Our Ref: BN/23/20/DOC

Approval of details reserved by condition imposed under ref BN/23/15/PL relating to Condition No 5 - surface water drainage, 6 - discharge of any flows to watercourses and 7 - future access & Maintenance of any watercourse or culvert

Coniston Lake Lane Barnham PO22 0AD

Record of As Bolt Construction

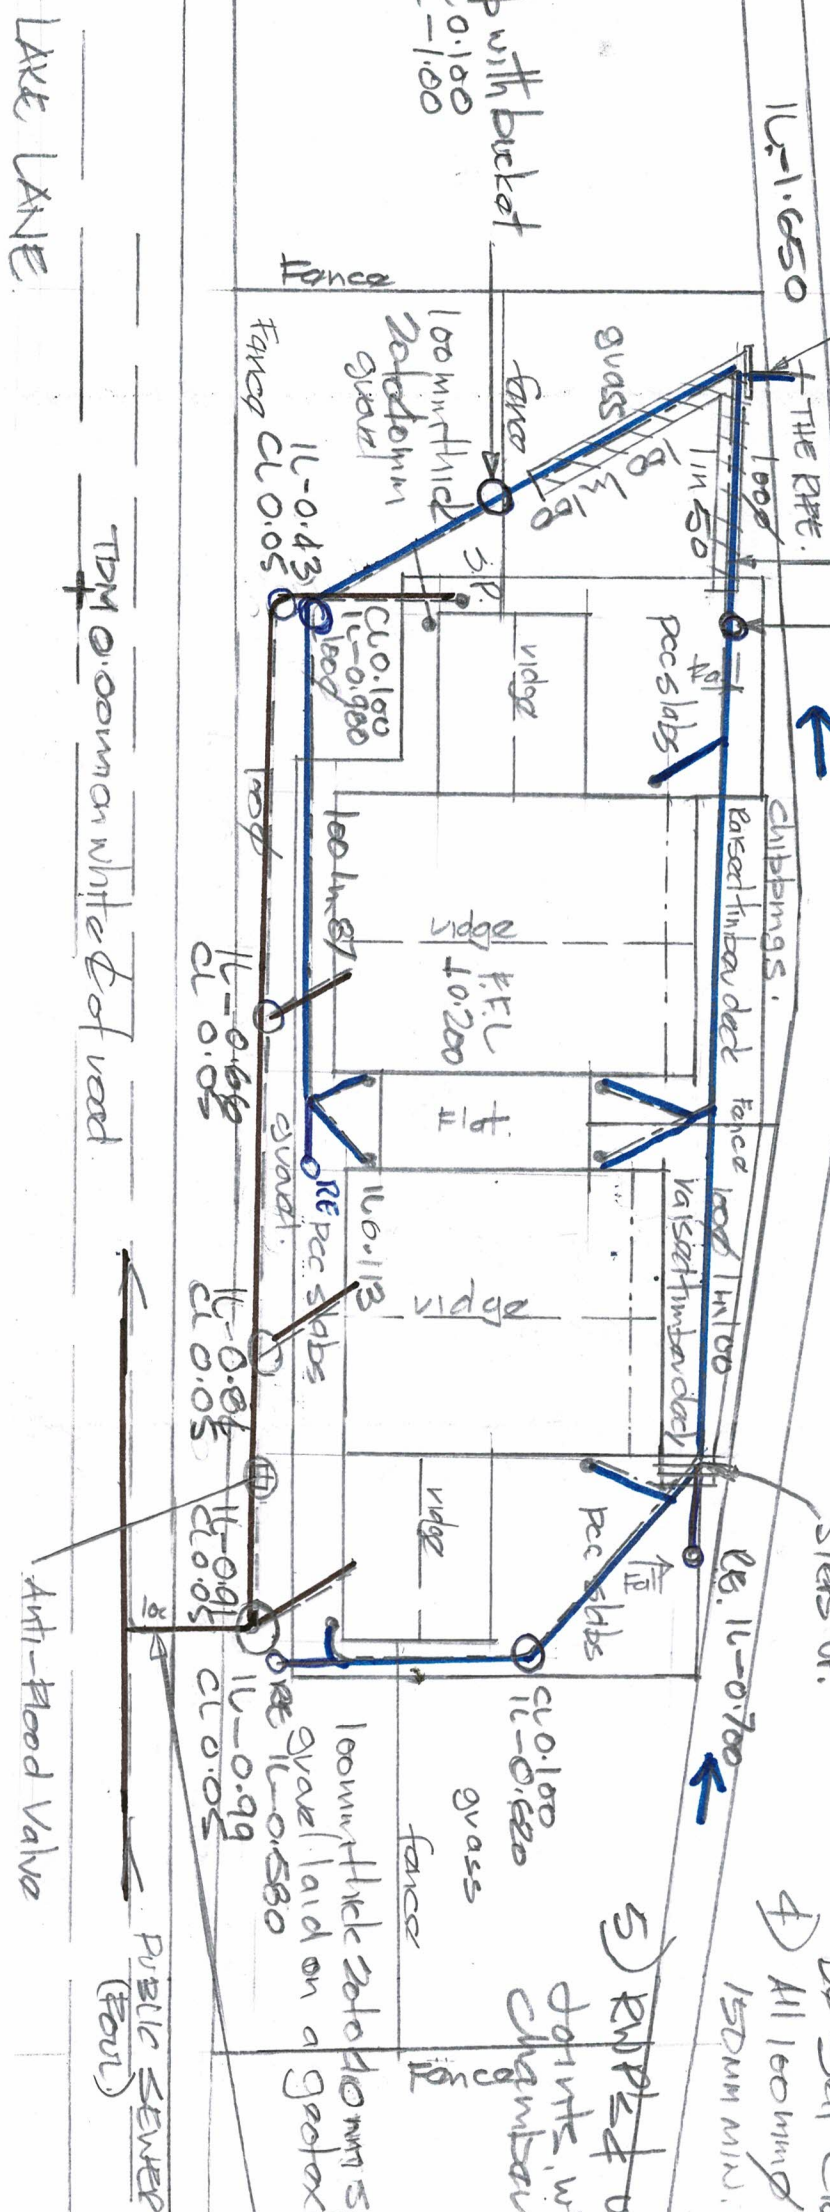
- Numerous invert levels have been changed. The invert level of the silt trap manhole is not clear (-0.900?), neither is the rodding eye invert level. Please provide clarity on the drawing.
- Revised drawing 535/02 has not been received.
